From: Simon Davis
Sent: 04 February 2026 17:28
To: Planning.Responses
Subject: FW: AL/3/26/DOC - SUB PLAN REQUEST
Attachments: Noise and Vibration Mitigation Strategy.pdf

From: Simon Davis <Simon.Davis@arun.gov.uk>
Sent: Monday, February 2, 2026 9:51:07 AM
To: Robert Collett <[REDACTED]>
Subject: AL/3/26/DOC

I have reviewed the submitted application for the discharge condition 24:

Title:	Site Execution Plan
--------	---------------------

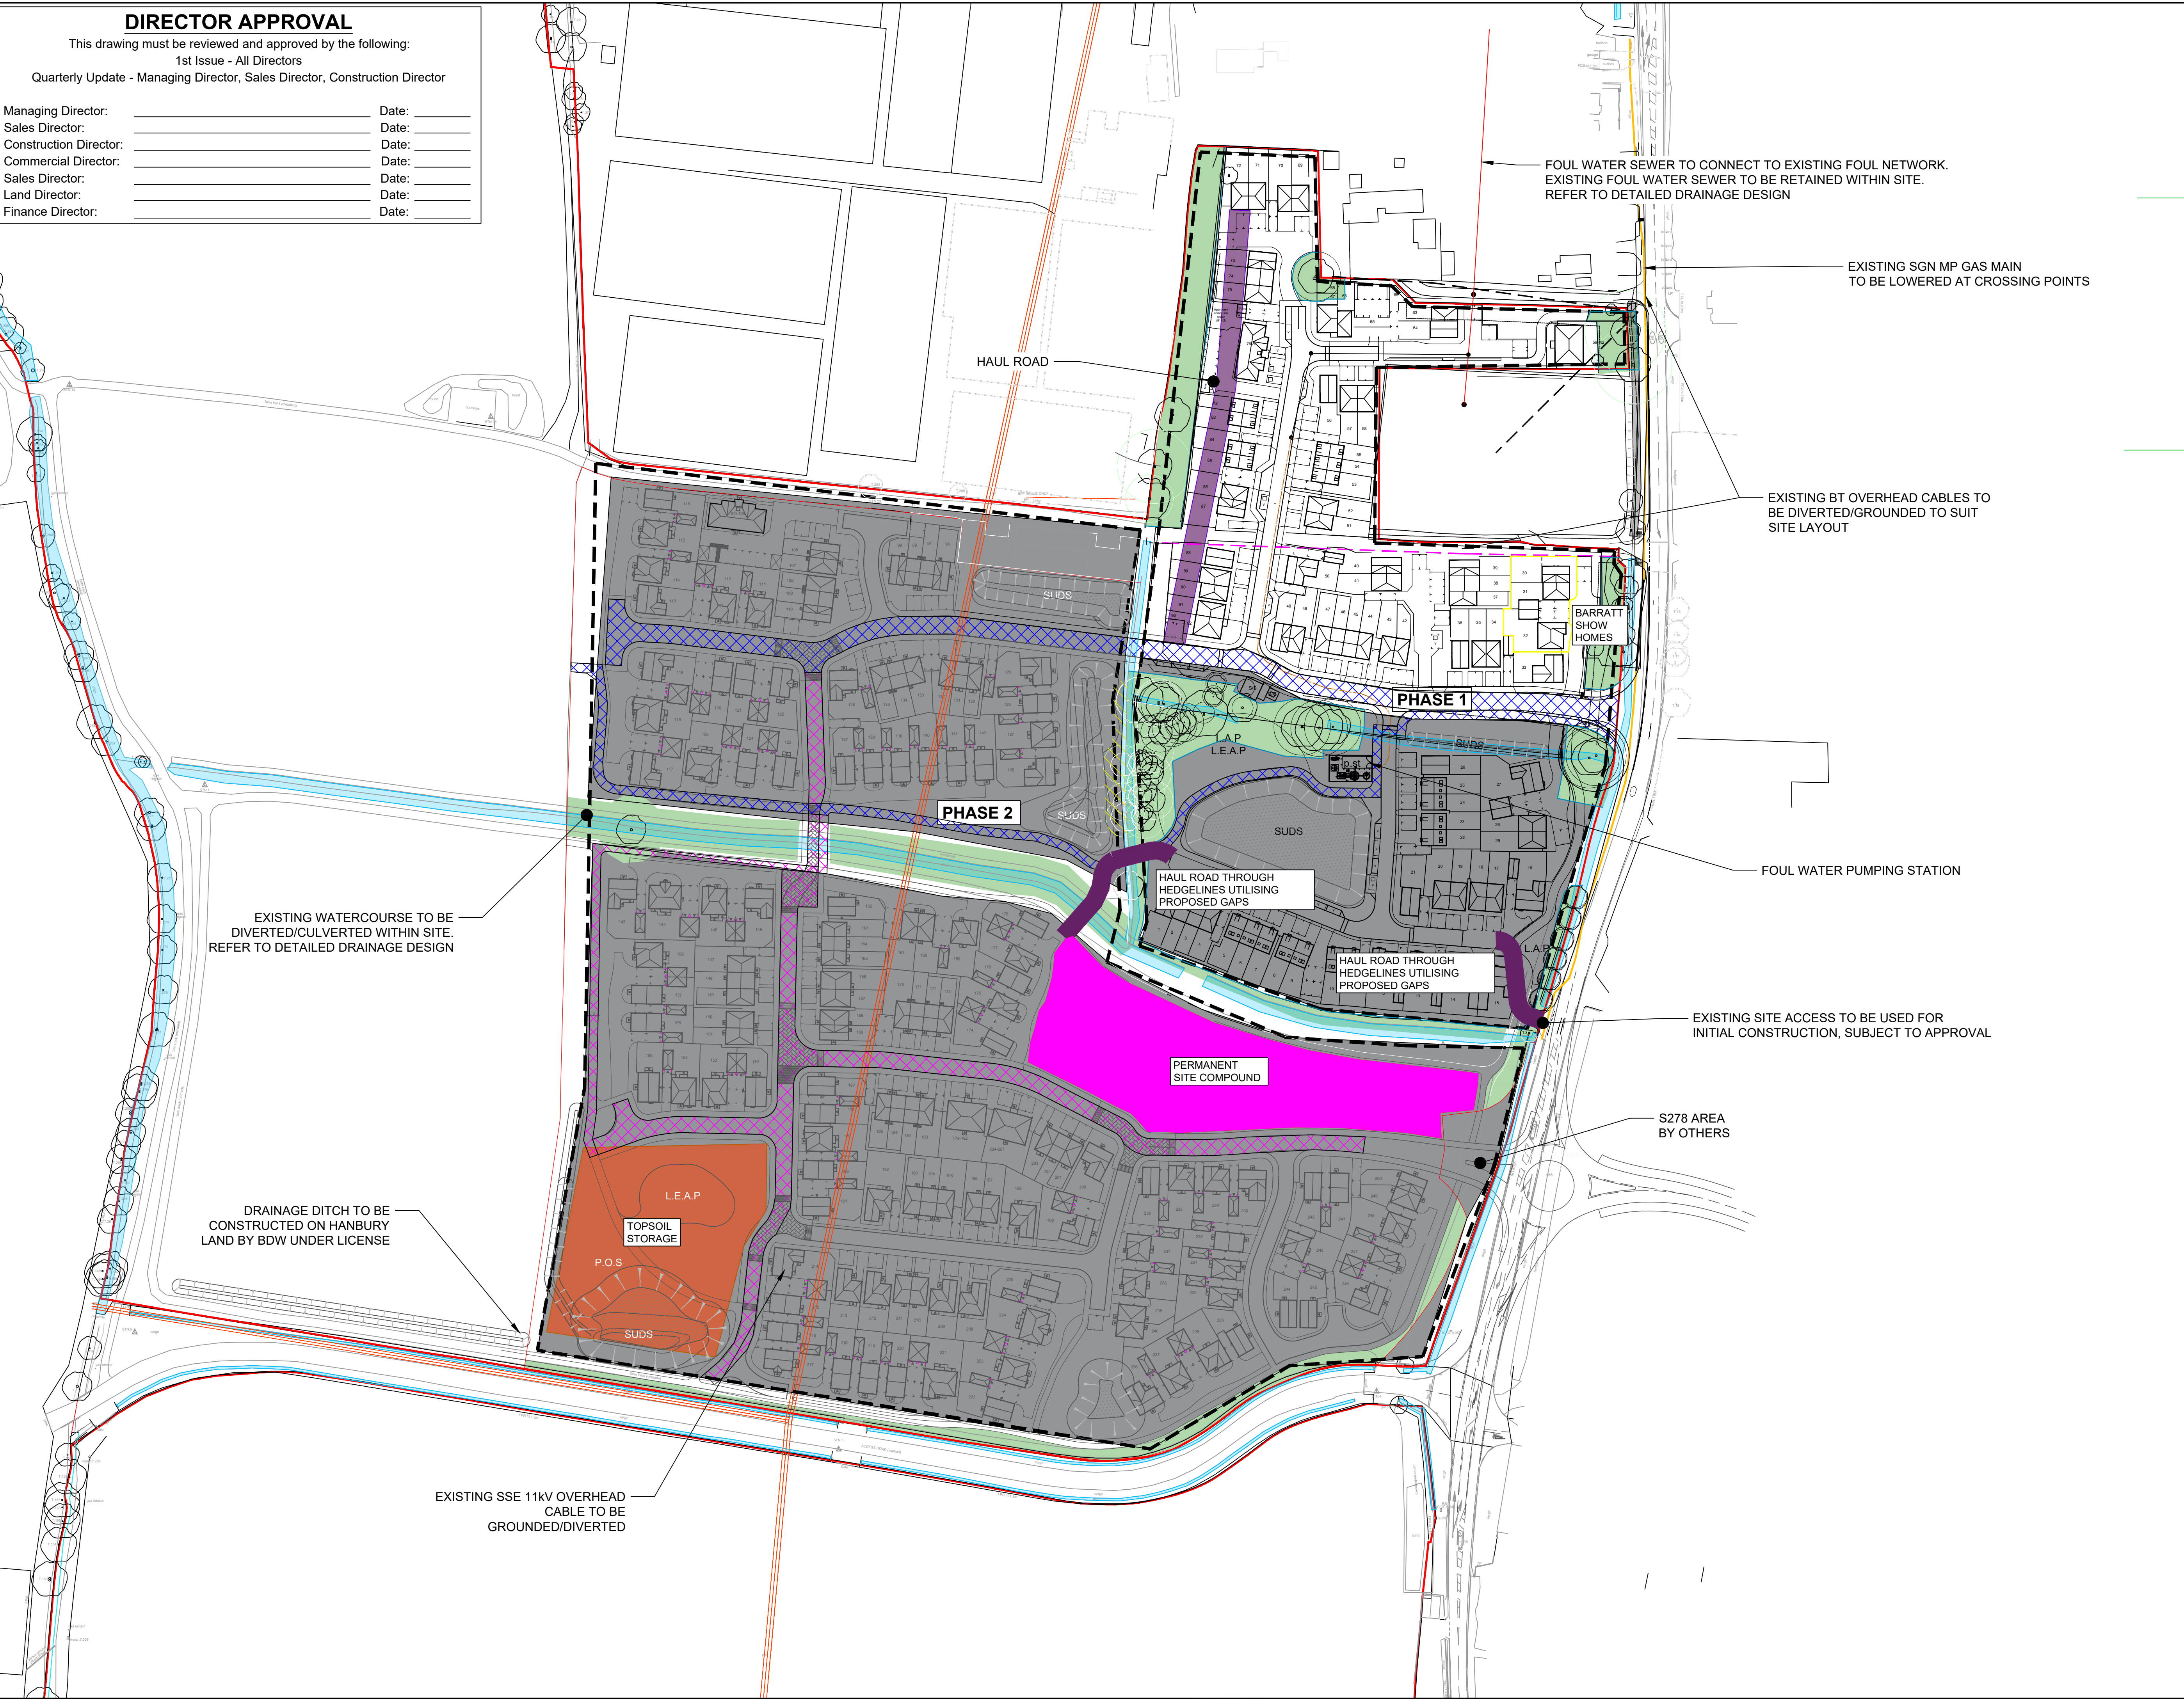
The applicant has submitted a standard CMP which is not sufficient to discharge this condition. The proposed development is going to be constructed over 7 years resulting in the first occupants to be

exposed to construction noise for a very long period of time and while we know that to some extent this is unavoidable, this condition was added to try and minimise the impact the construction noise will have. To be able to discharge this condition we need to see what additional steps are going to be taken to try and protect the early occupants beyond just the standard CMP.

Thanks for the below. Can I just clarify that the 7 year reference are phases 1 and 2 combined, rather than the current application in isolation, where the construction period for 93 dwellings would be much shorter, just over 2 years.

The measures set out in the CMP are those measures normally employed to protect amenity, including existing residents and those living on site during the construction process. Are you able to direct me to any other measures for a similar condition that have been approved?
